Begbroke and Yarnton Green Belt Campaign (BYG)

Deadline 2: BYG WRITTEN REPRESENTATION 4

Comments on Deadline 1 WR from Historic England (HE)

**Botley West Solar Farm**  
 Historic and Scheduled Sites Plan  
 Sheet 8 of 24

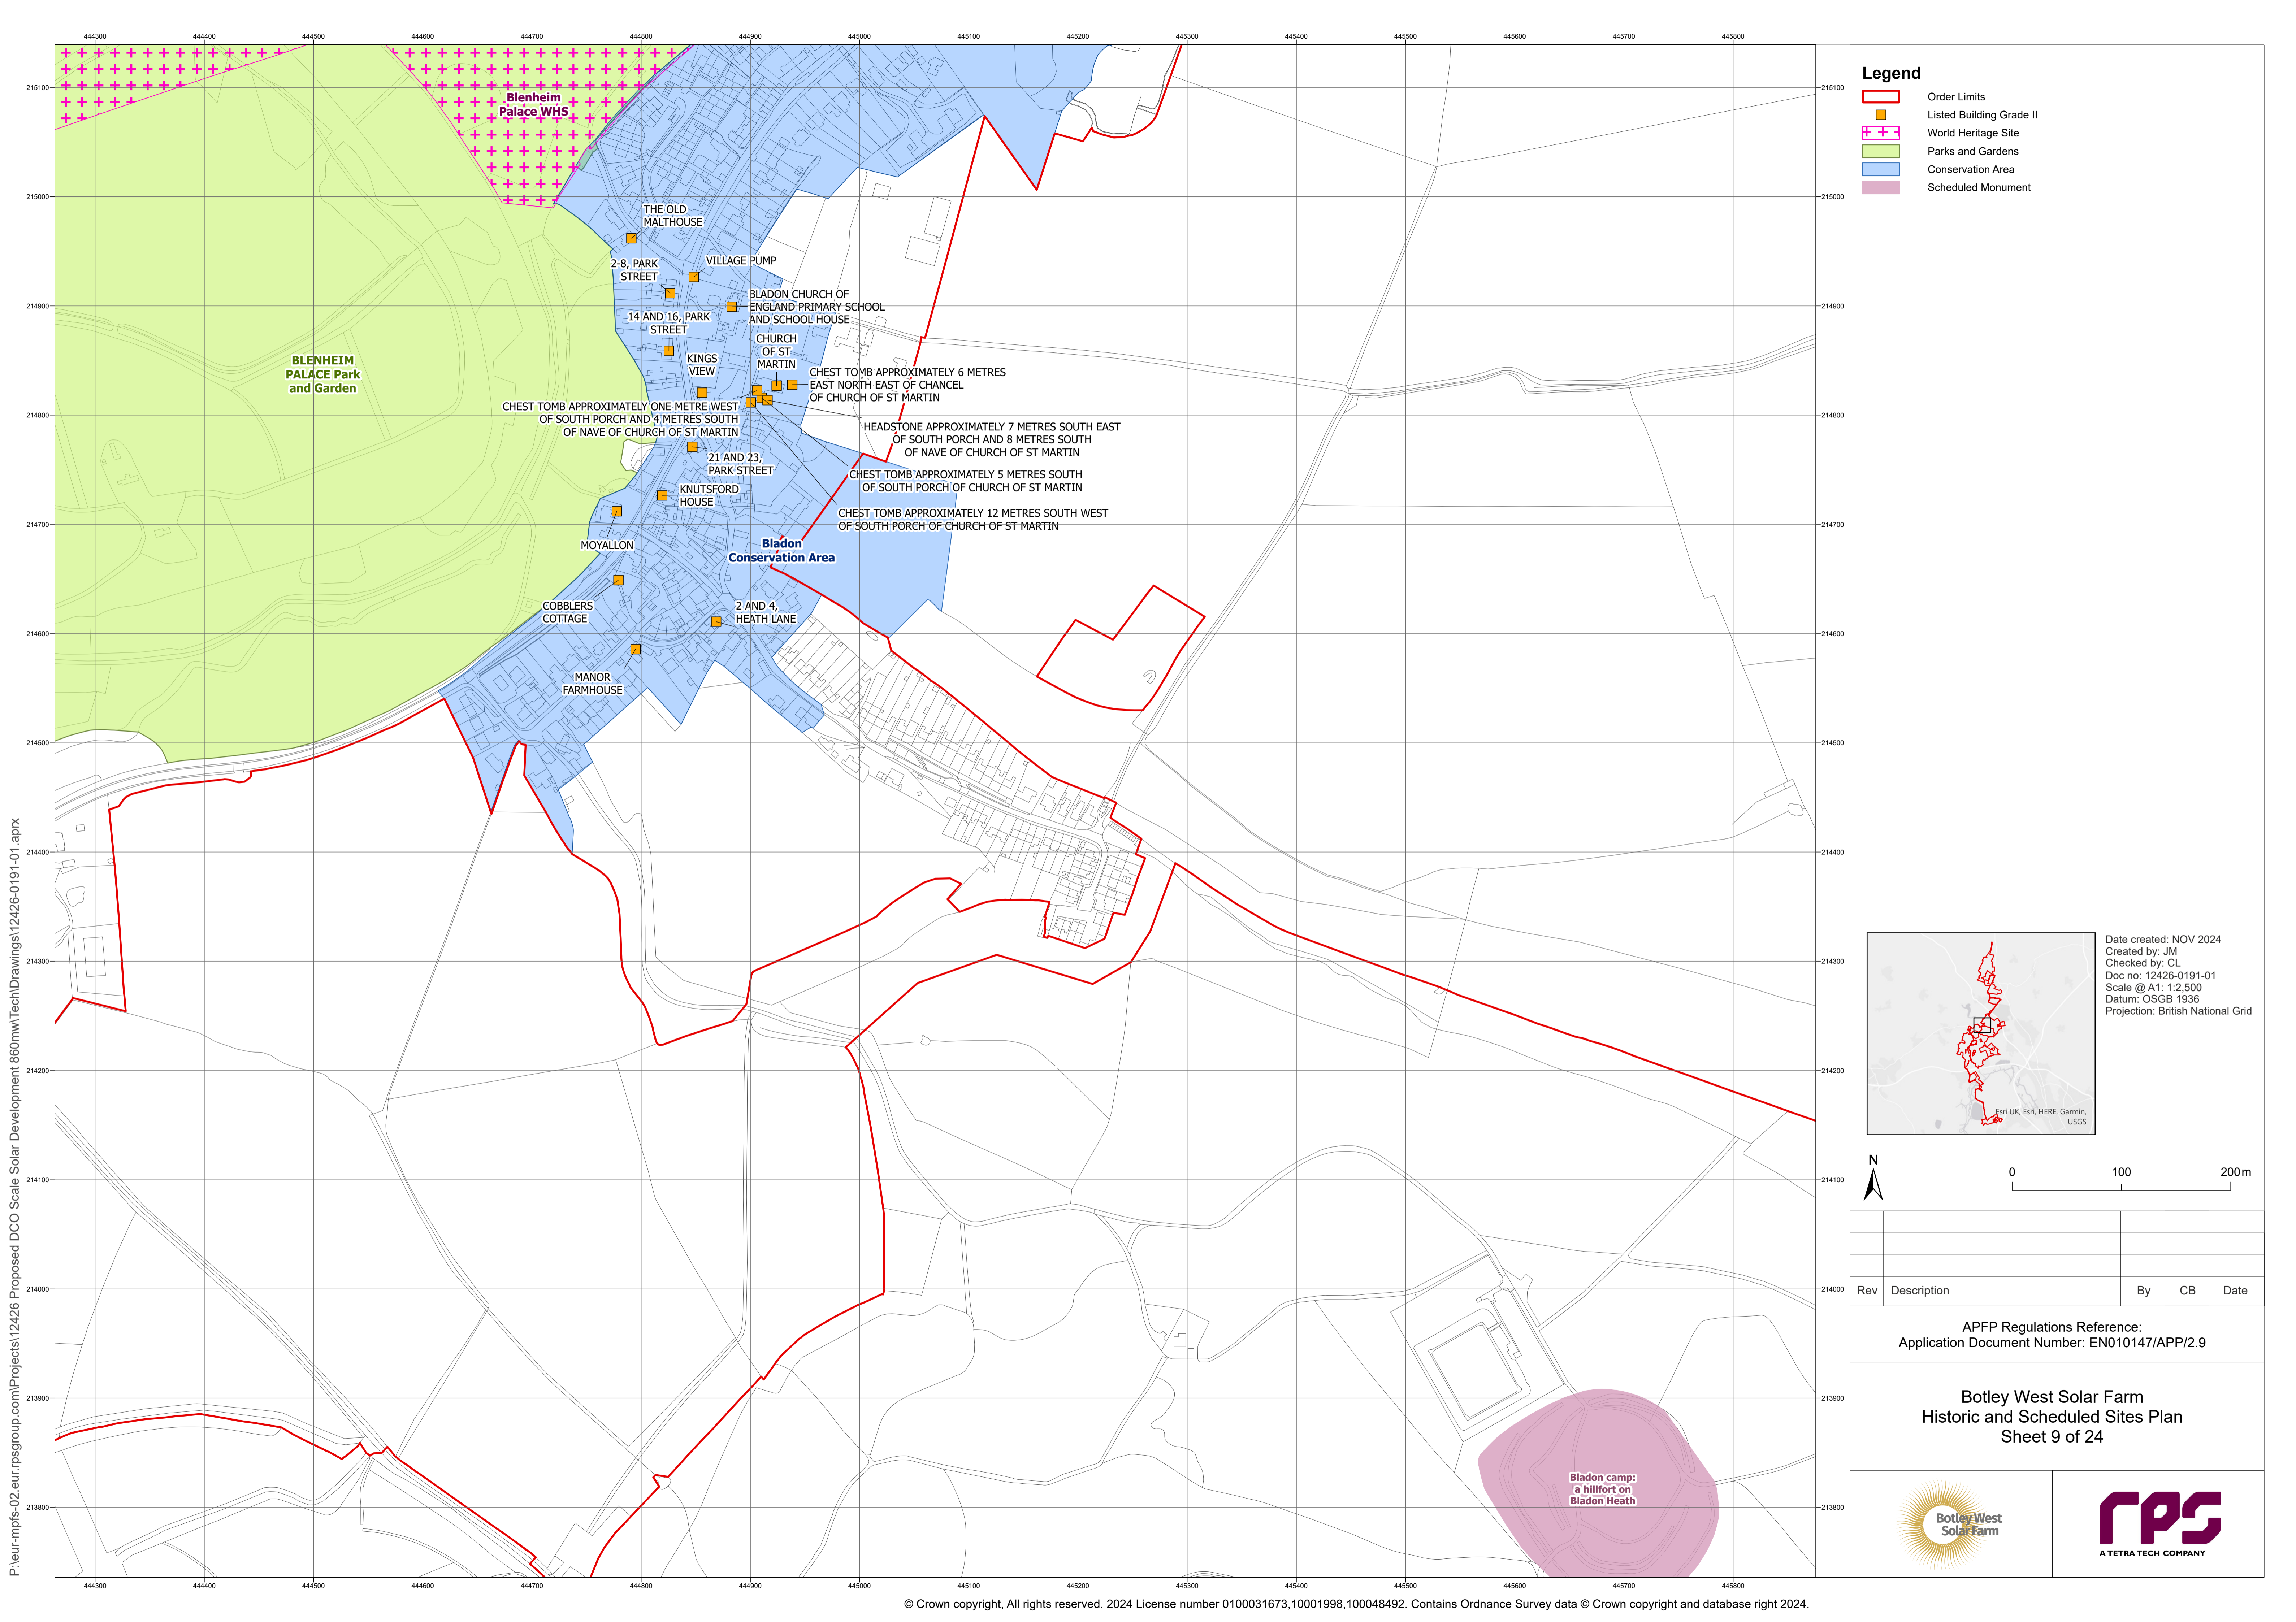
5. On the contrary, HE simply concludes (8.2) that any harm to the OUV will be avoided by "*removing the solar panels from the fields immediately to the south of Bladon*". There is no caveat offered regarding the views expressed by ICOMOS.
